## **BCA ASSESSMENT REPORT**

**OAKDALE SOUTH ESTATE  
SITE 3A - SIGMA  
MILNER AVENUE, HORSLEY PARK**

Revision 4

Date: 16.02.2018

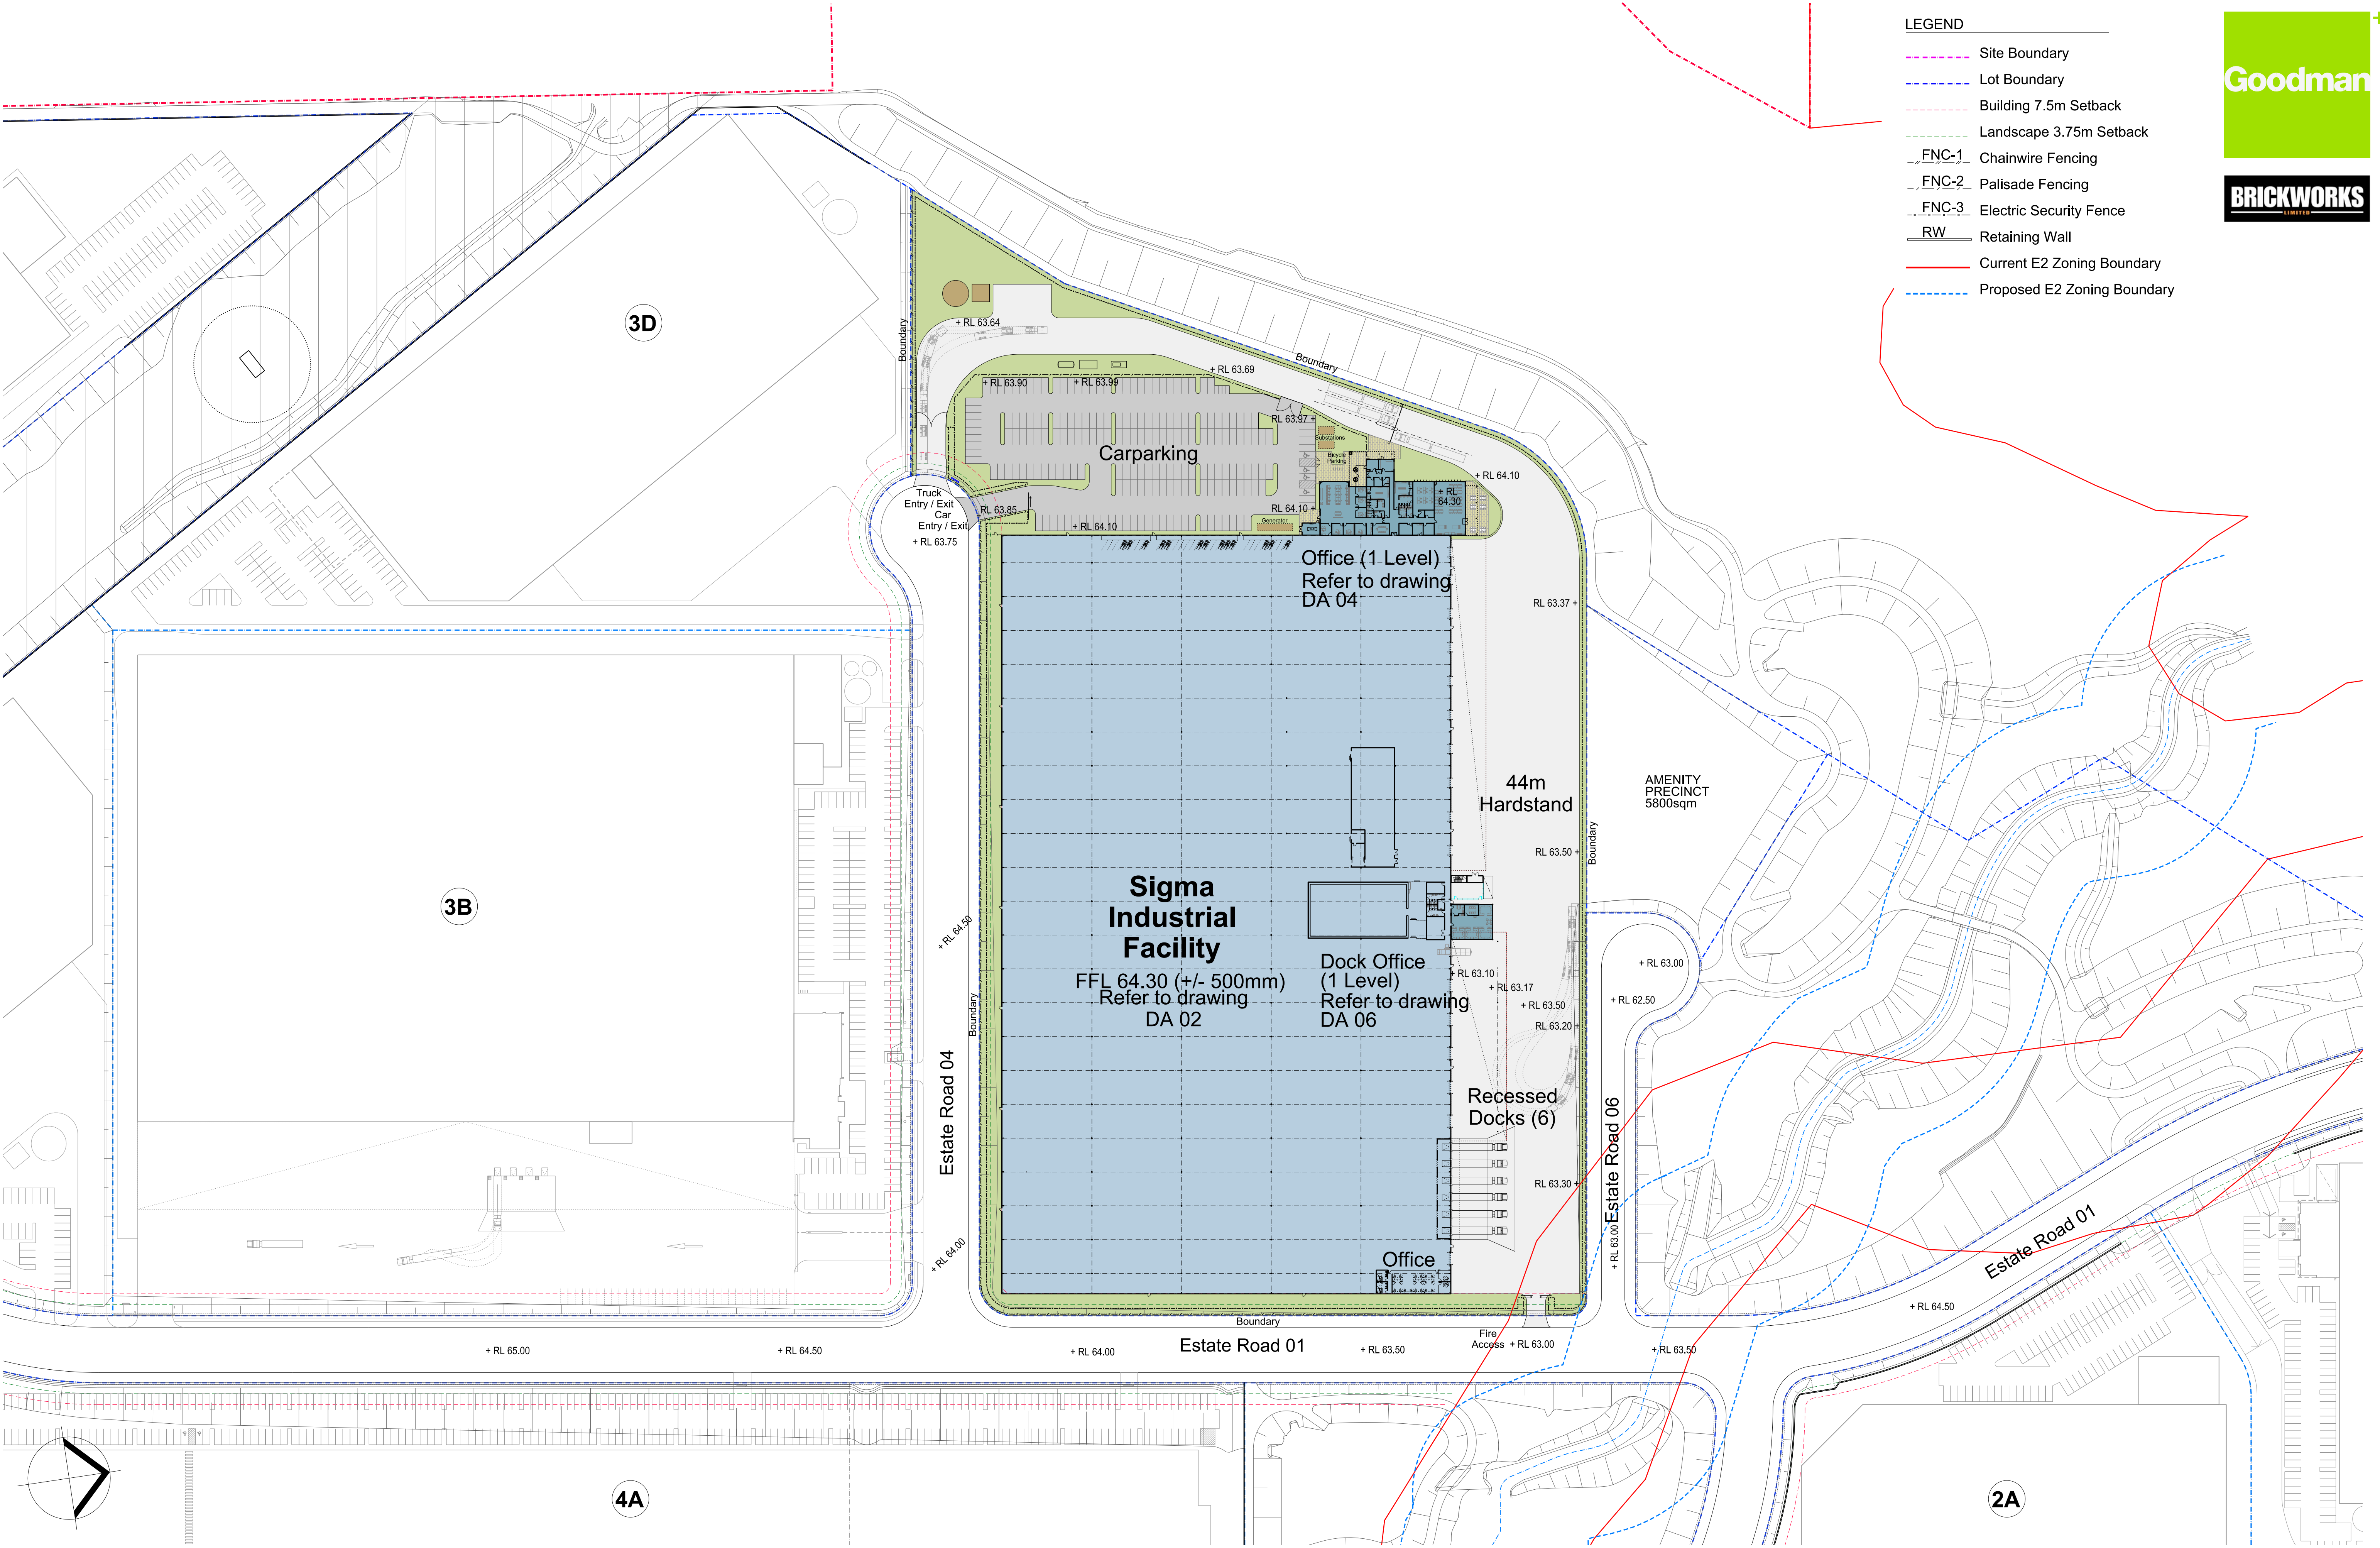
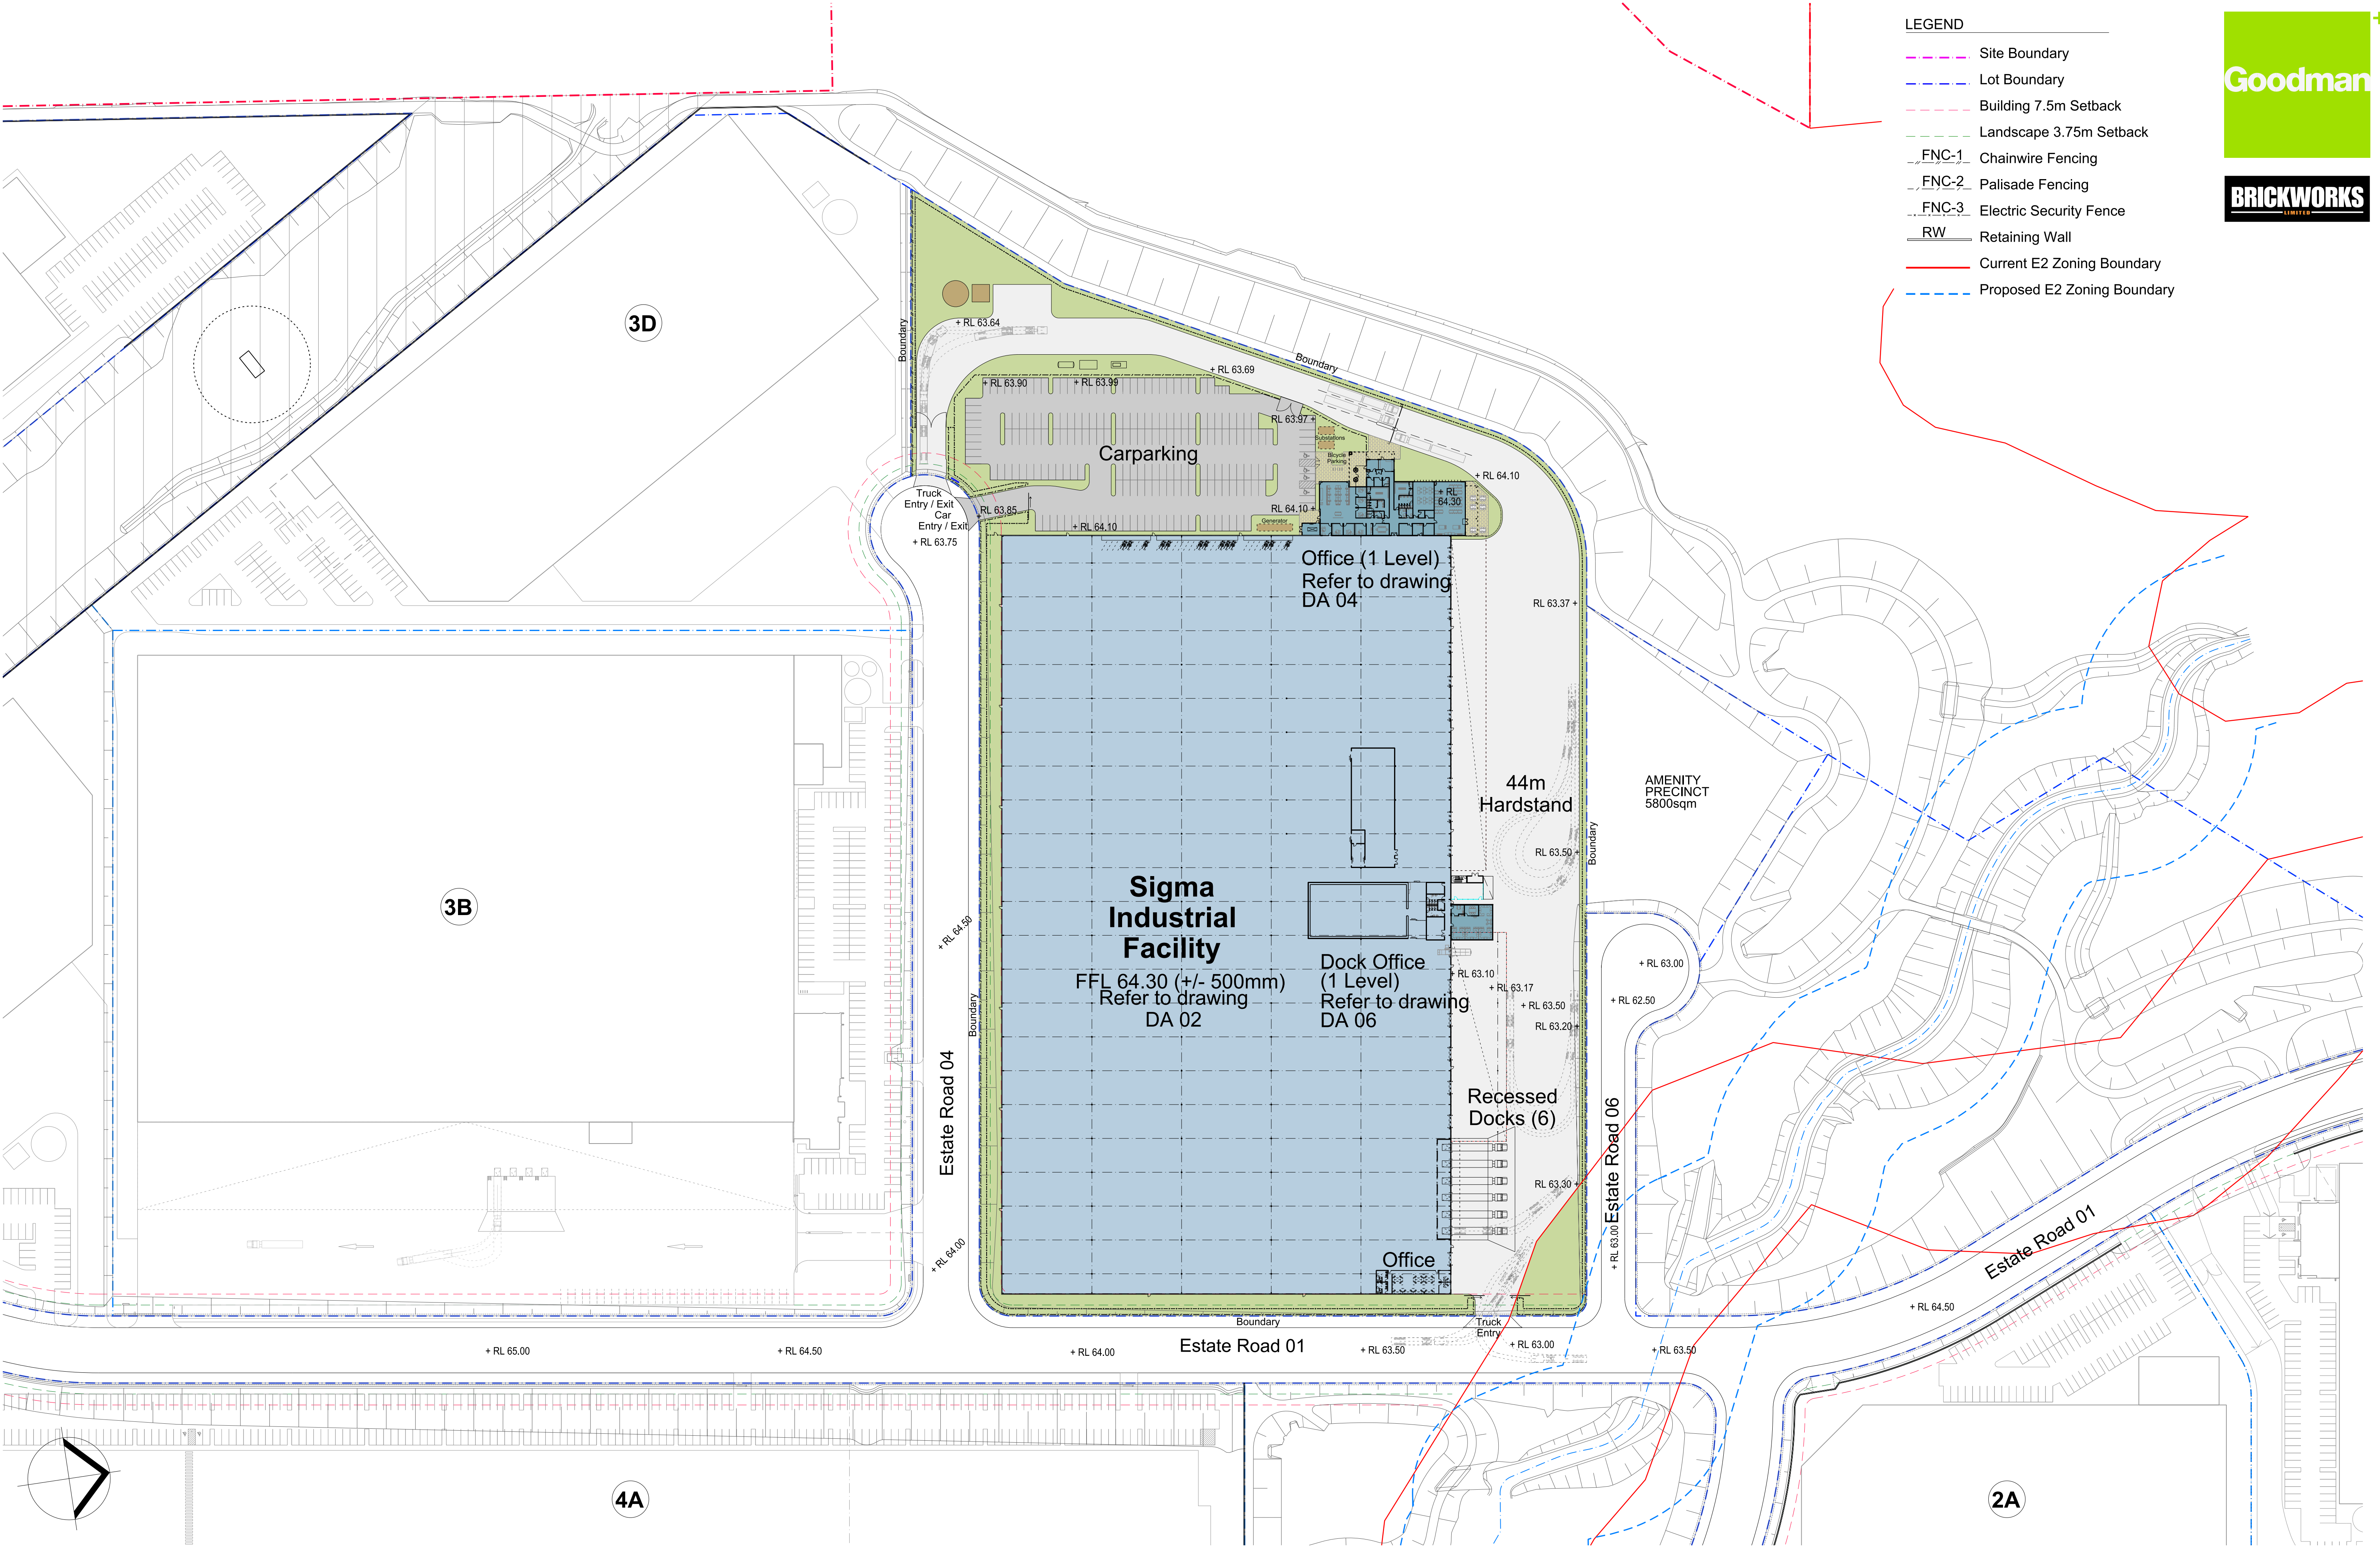
*Comments:* It will be necessary for an alternative solution to be prepared to address these non-compliance issues below, in order to demonstrate compliance with Performance Requirement CP9. The departures from this clause are as follows:

- + The vehicle access in the SW corner and western side of the building is greater than 18m from the building as identified below.
